State of Washington
DEPARTMENT OF FISH AND WILDLIFE

November 30, 2023

SUBJECT: WDFW COMMENTS ON RU-23-00001 Teanaway Ridge

**Project RV Resort**  
 A Recreational Vehicle Resort on the Yakima River  
 Kittitas County, Washington  
 JANUARY 202011

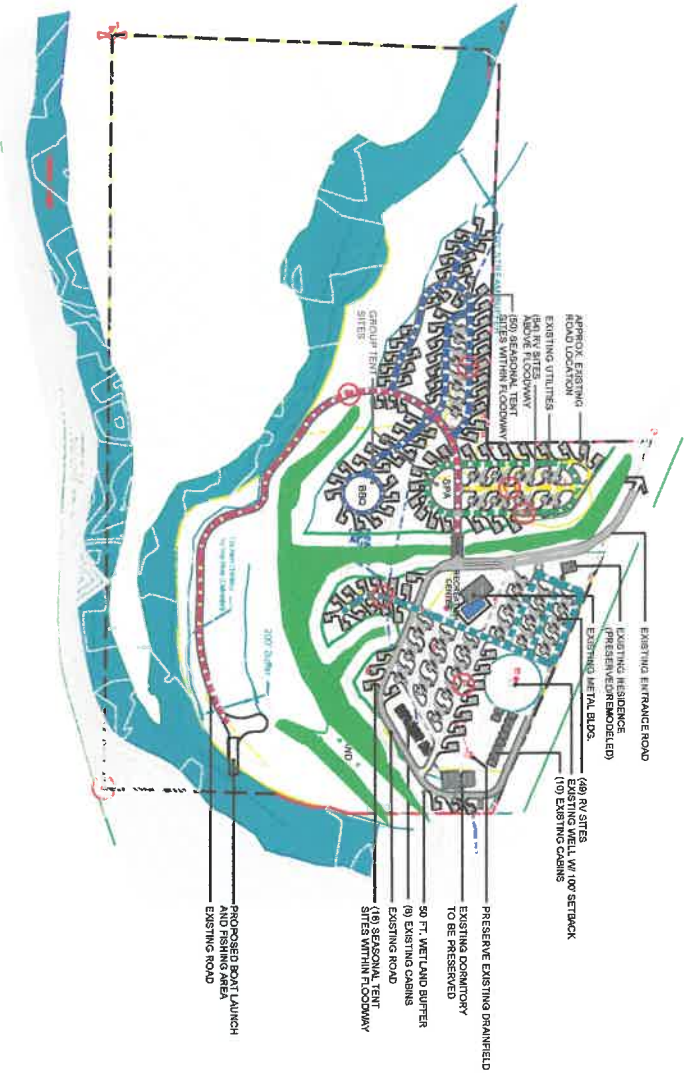
We appreciate the work the project proponents have completed to better understand the critical areas on the property, including the potential for Channel Migration onto the property. With this information, the proponents have described a substantial decrease in the proposed development of the Yakima River Campground Conditional Use Permit (CU-15-00002) near the Yakima River and the riparian habitats based on the narrative provided. However, there is no updated site plan to review, making it difficult to fully evaluate for potential impacts to critical areas functions and values. **We request an updated site plan that clearly shows the new proposed layout for the site prior to approval to ensure we understand the proposal and potential for impacts to critical areas.**

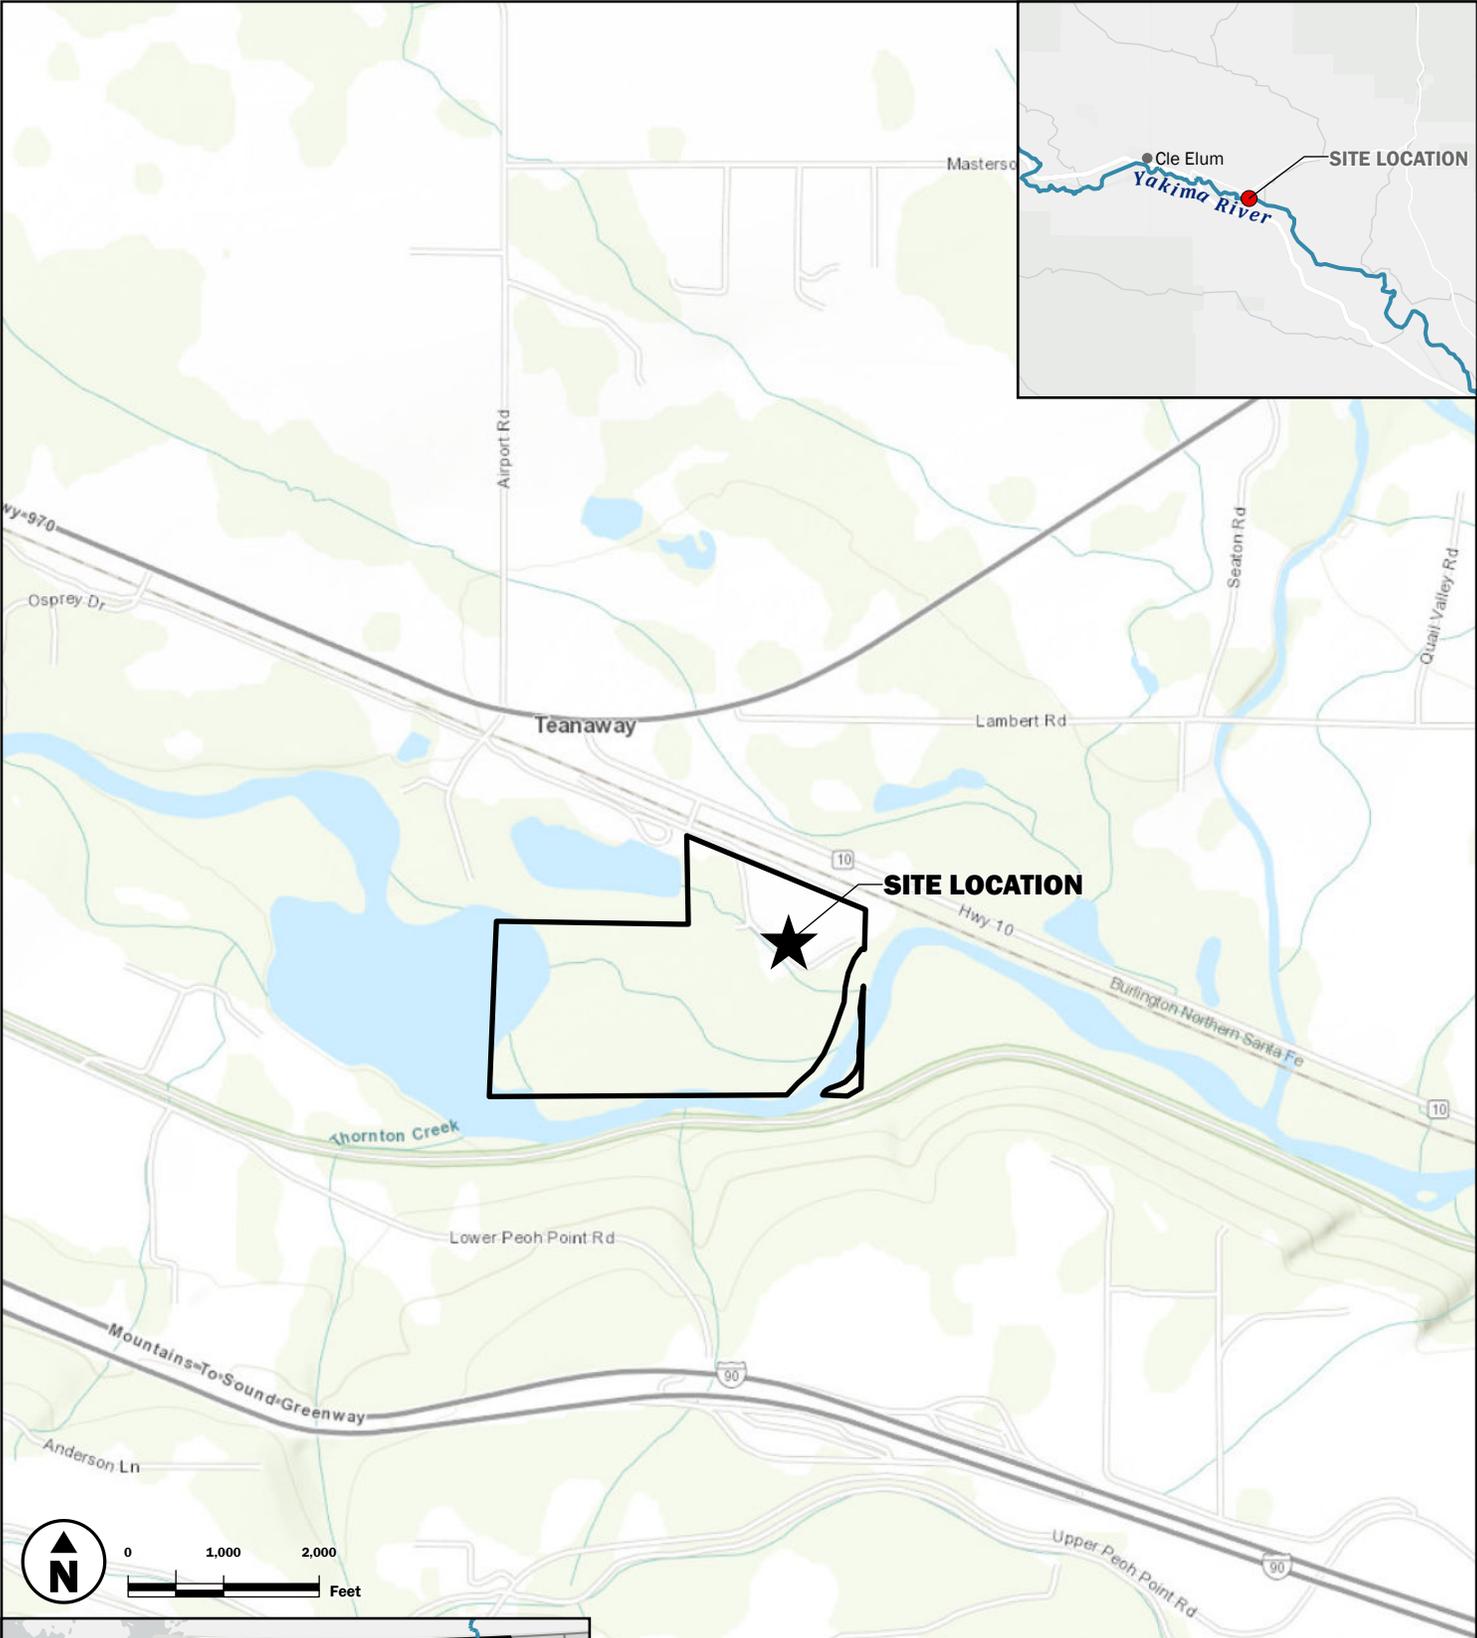
The Channel Migration Zone Summary Memo clarified the potential for lateral migration at the project location. The report identifies more rapid migration near the western portion of the property and the

properties immediately upstream of the subject parcels but does not assess the potential for an avulsion on the WDFW property that could travel through the adjacent pond and onto the western portion of the property. In June 2022, flood waters breached the berm of the pond and flooded the northwestern portion of the property where several RV sites have been proposed in previous site plans. WDFW has experienced more frequent flooding of the road to our water access site upstream of this project site and to the best of our knowledge, the pond berm has not been repaired. We believe there is a relatively high flood risk on the northwestern portion of the property (see photos in our 2022 letter) that is not reflected in the information available to review. **If the northwestern portion of the property is proposed for development in the new site plan, we request further evaluation of the potential for avulsion and/or flood risks through this area.**

**Figure 1.** This image was part of WDFW’s comments in 2016 for the Yakima River Campground (CU-15-00002, SD-15-00001, SP-15-00001).

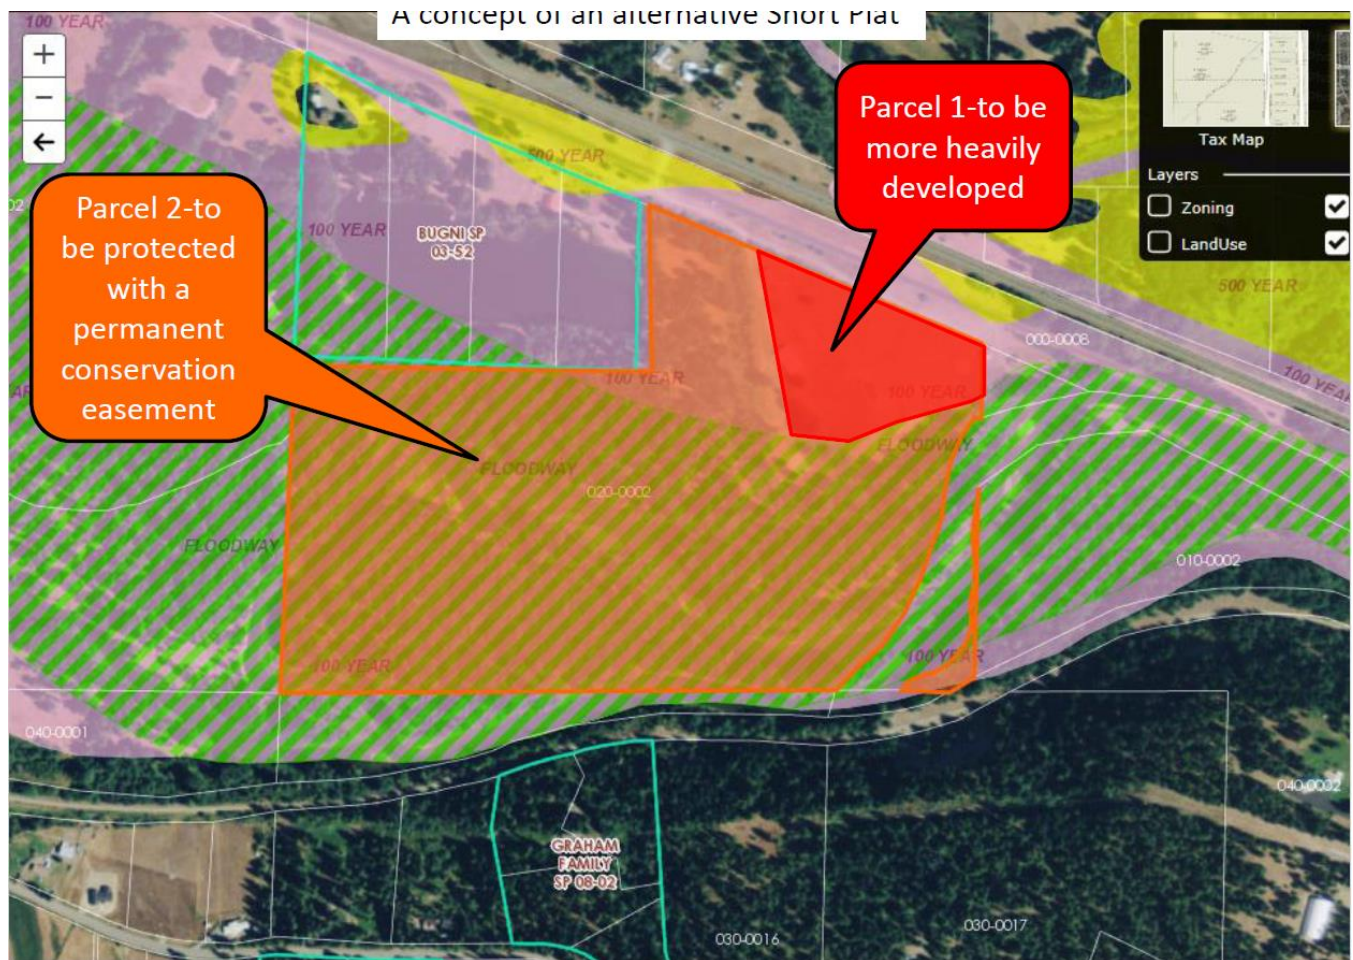
Without an updated site plan and based on the information provided in the updated critical areas report and CMZ summary along with the existing infrastructure, **WDFW believes the image presented in our 2016 comments for the Yakima River Campground Conditional Use Permit (Figure 1) represents the area most suitable for a Reasonable Use Exception on this property and meets the intent of KCC 17A.01.060(2).**
